Phone: 0300 123 6780
Email: Kathryn.Walsh@lancashire.gov.uk
Your ref: 3/2024/0942
Our ref: 3/2024/0942/HDC/KW
Date: 11 February 2025

Location: Black Moss Farm Elmridge Lane Chipping PR3 2NY
Proposal: Proposed conversion of two stone barns to create three holiday cottages with associated curtilages.
Grid Ref: 360123 440456

Summary

No objection subject to conditions

1 Planning - Barn Conversions Proposed Site Layout
 Scale: 1:200

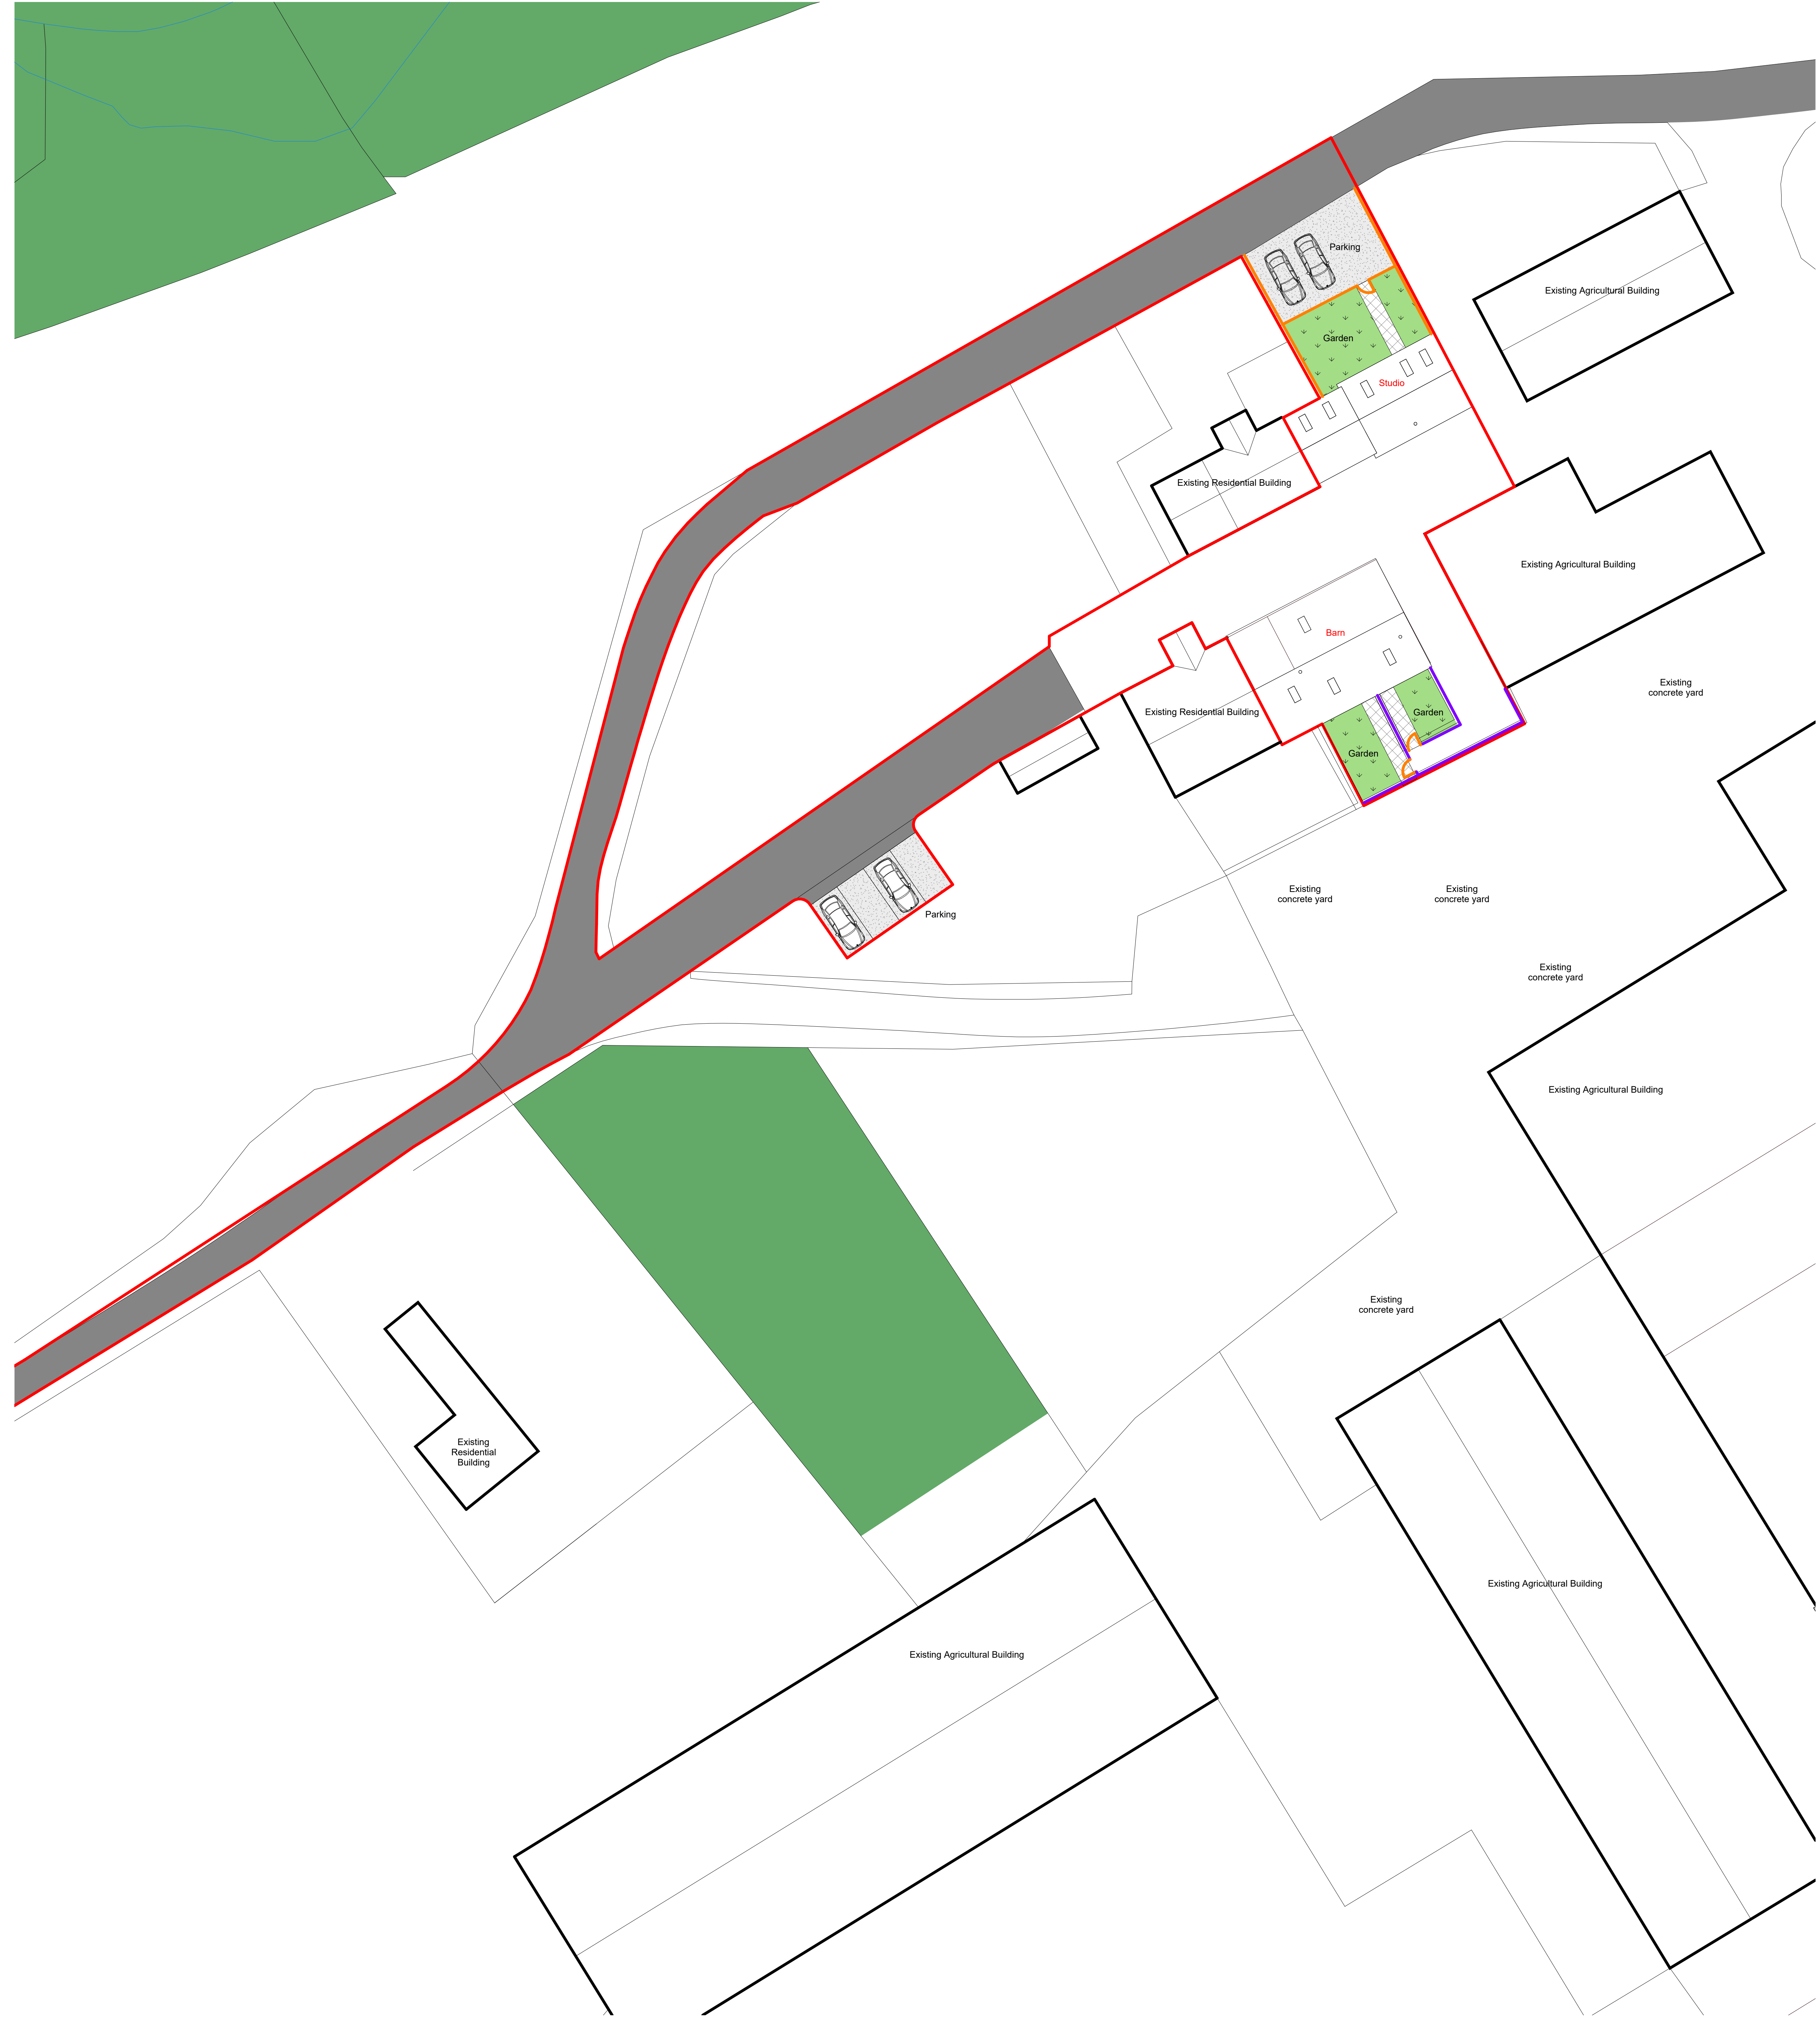
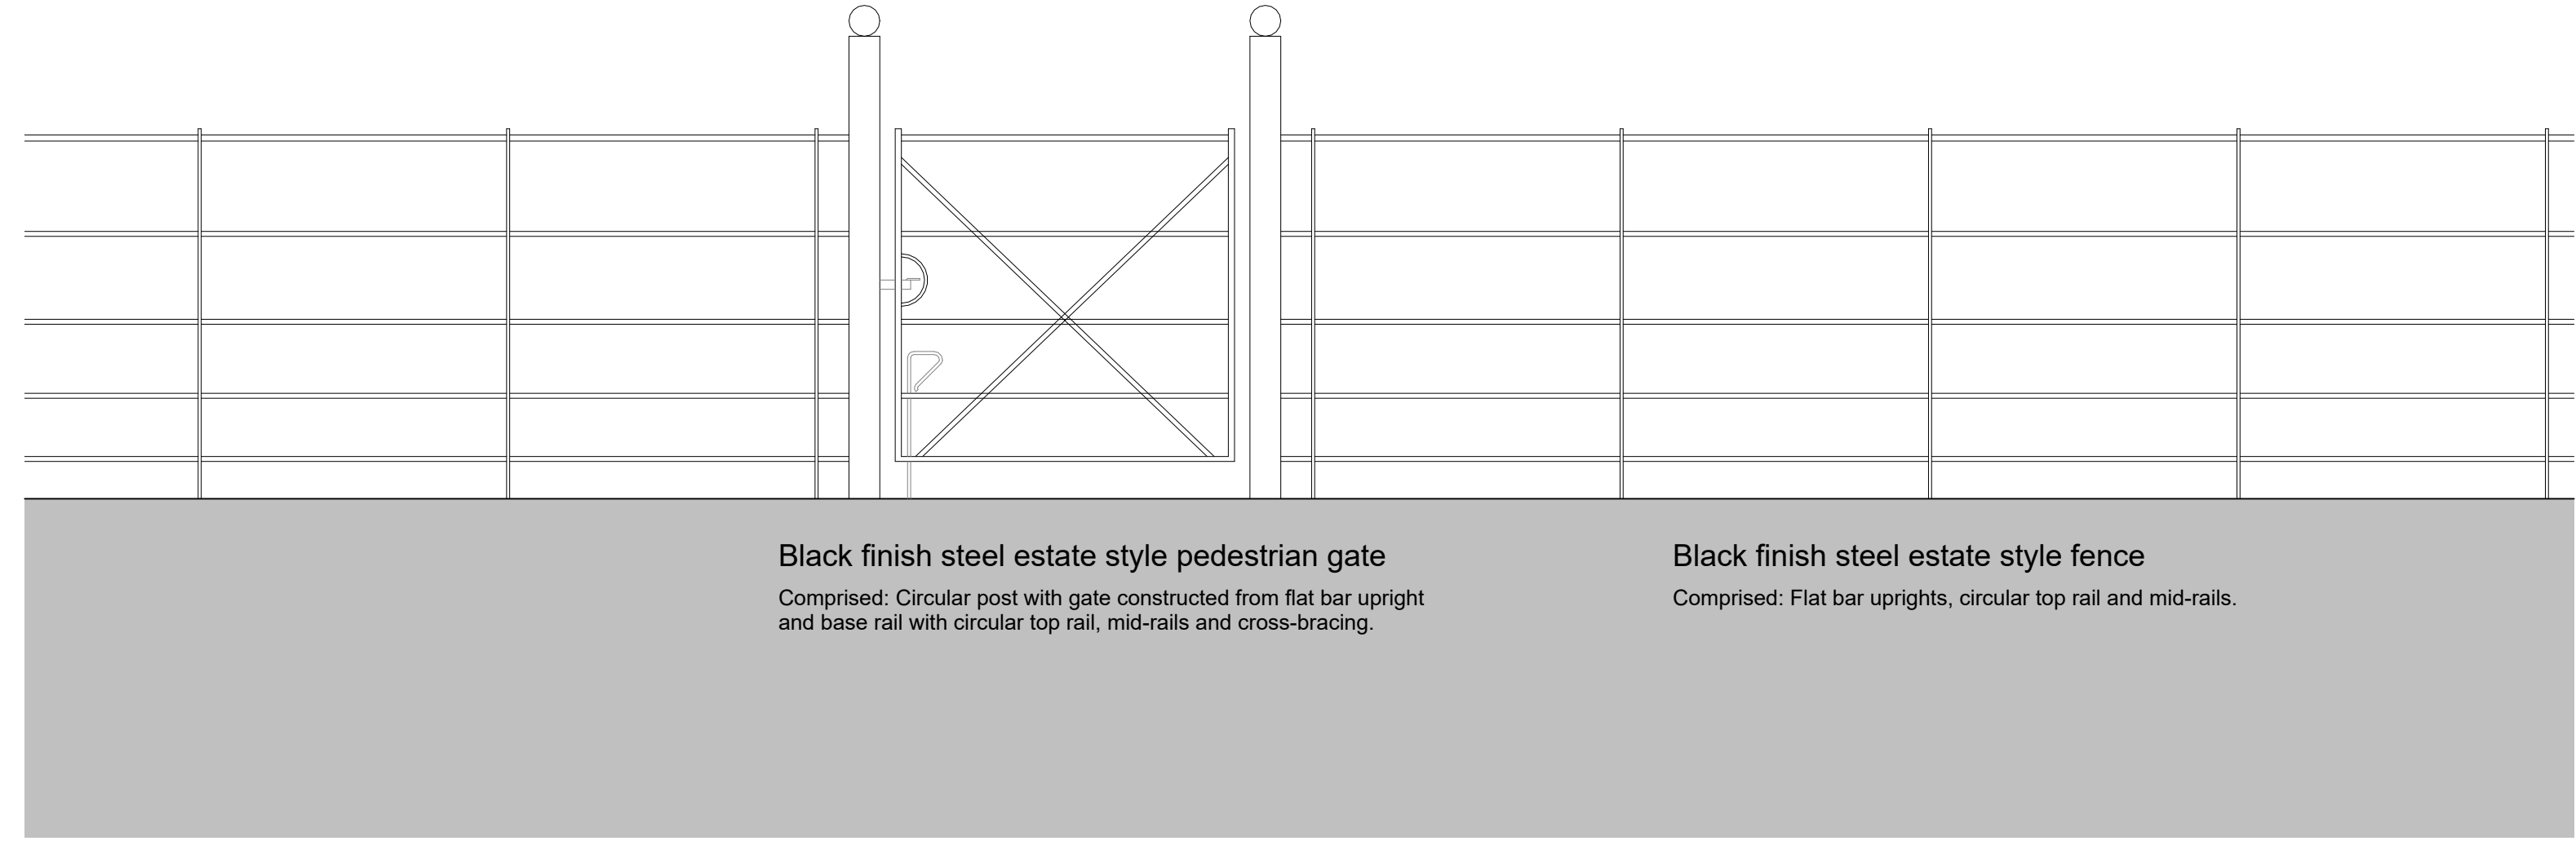
The LHA has reviewed drawing number P.02-P32 Revision P1 titled Proposed Site Layout and are aware that the holiday Barns and Studio comply with the LHAs parking standards as defined in the Joint Lancashire Structure Plan. There is also room to turn within the site and leave in a forward gear.
